Your Ref: OWPC25547
Our Ref: EP/160/19/PL 04-12-2019
Please ask for:
Zac Denton

Demolish redundant external store and former outside toilet at rear of 43 Sea Road and construct a single storey extension to create a 2 bedroom apartment.

Land to the rear of 43 Sea Road East Preston

SIDE (S) ELEVATION 1:100 @ A3

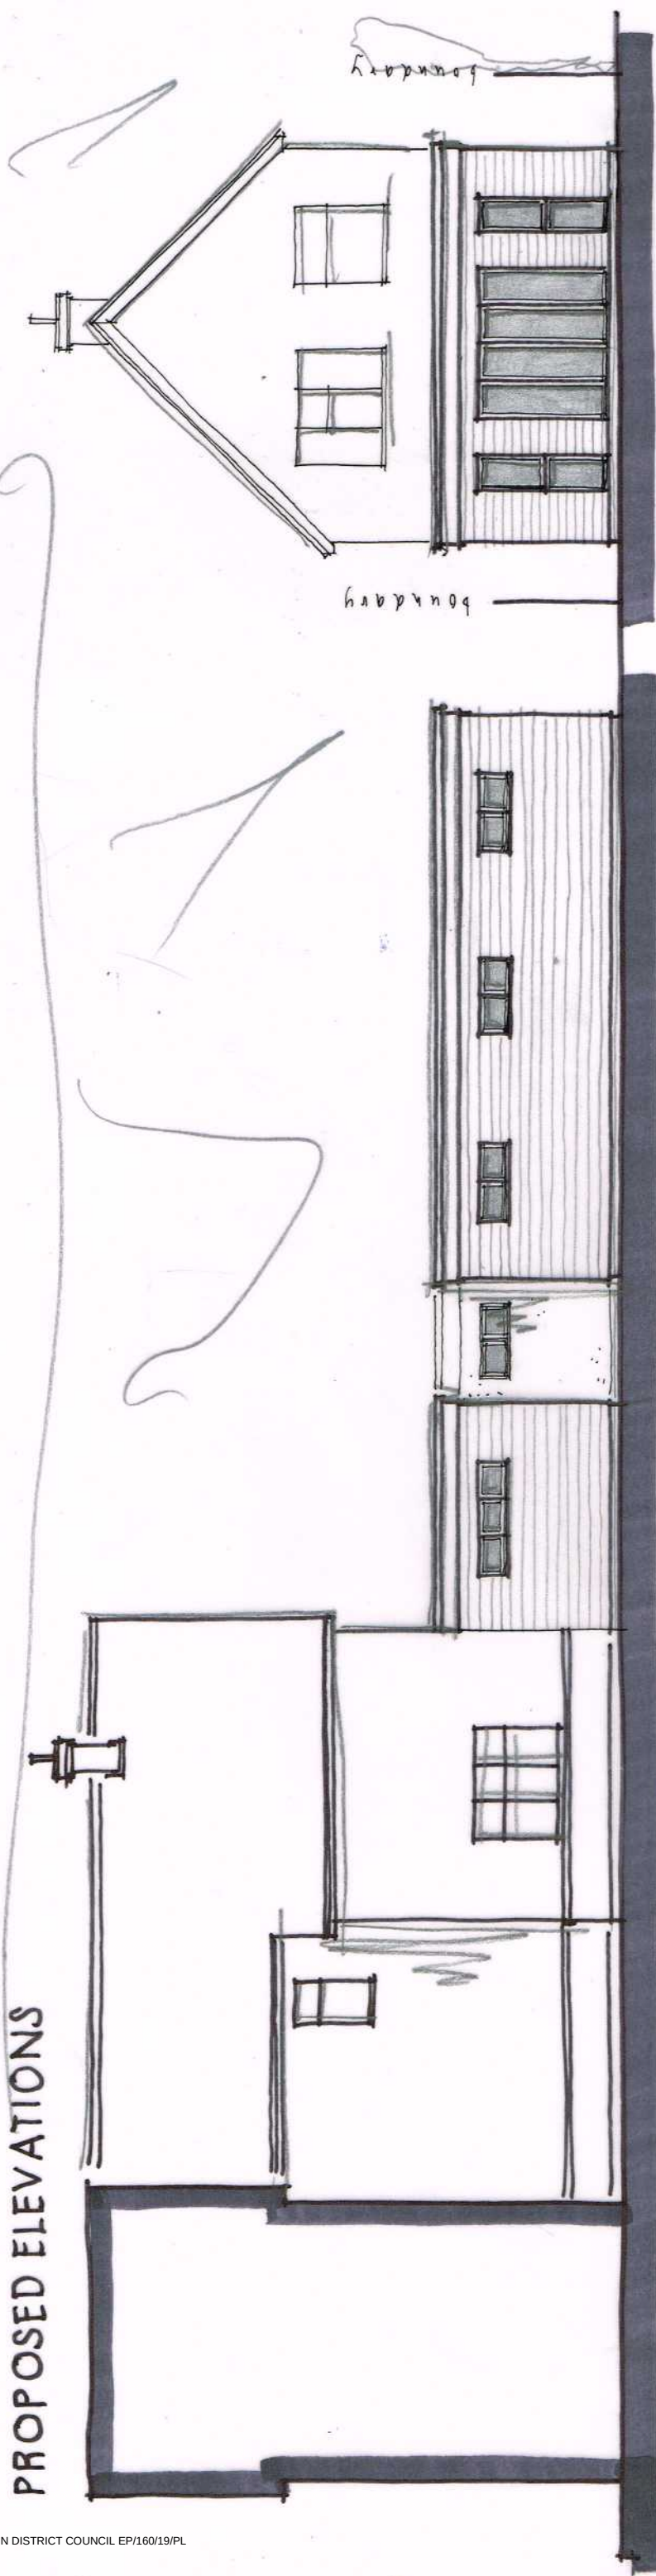
1 - The proposed windows on the south elevation of the property, 1m away from our boundary fence, will cause light (and potentially sound) pollution to ourselves and neighbouring properties in Vermont Drive.

7 - The proposed wood clad exterior walls, great powder coat windows and large flat roof is not in keeping with local buildings and other buildings located within the local area.
